**Planning Department  
Transportation Development Services Section**

**Re: San Antonio Commons, 5700 San Antonio Dr. NE**  
**Certification Submittal for CO – Transportation Development**  
Engineer's/Architect's Stamp dated 8-07-08 (E18-D059)  
Certification dated 3-25-14

GRADING AND DRAINAGE PLAN

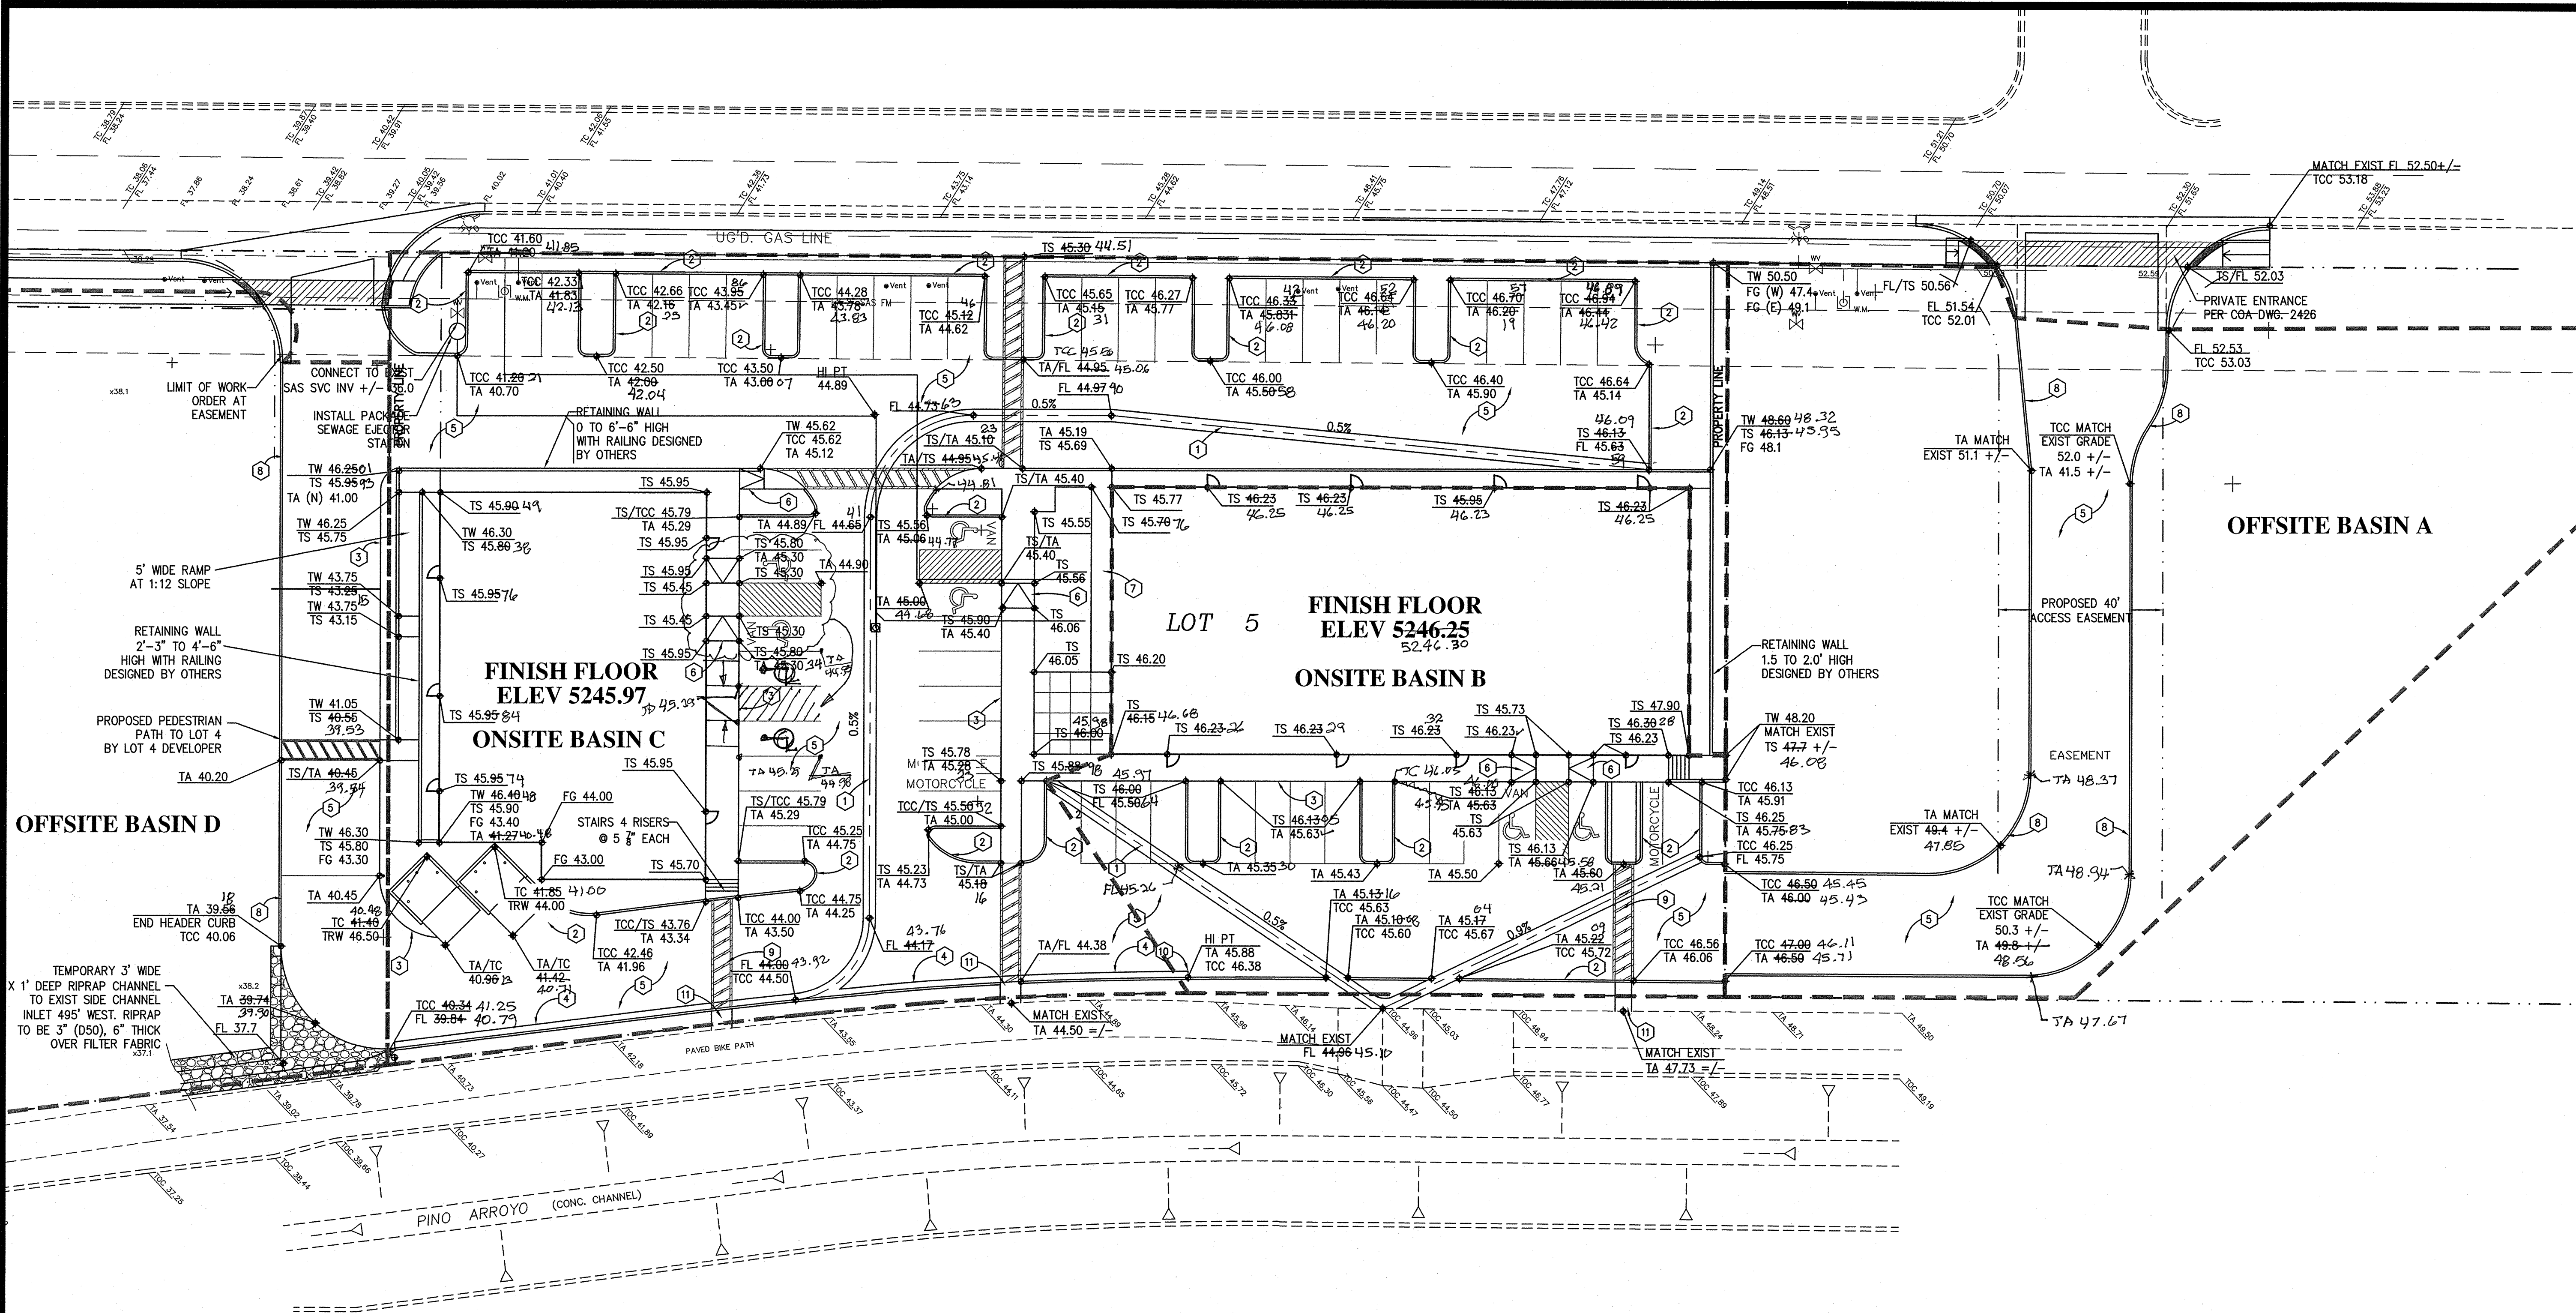
- The ADA accessible parking spaces did not have signs hung.
- The crosswalk connecting Building B to the Pino Arroyo Path needs to be defined by striping or stamped concrete.
- Redline any crosswalks that have not been installed in submittal.
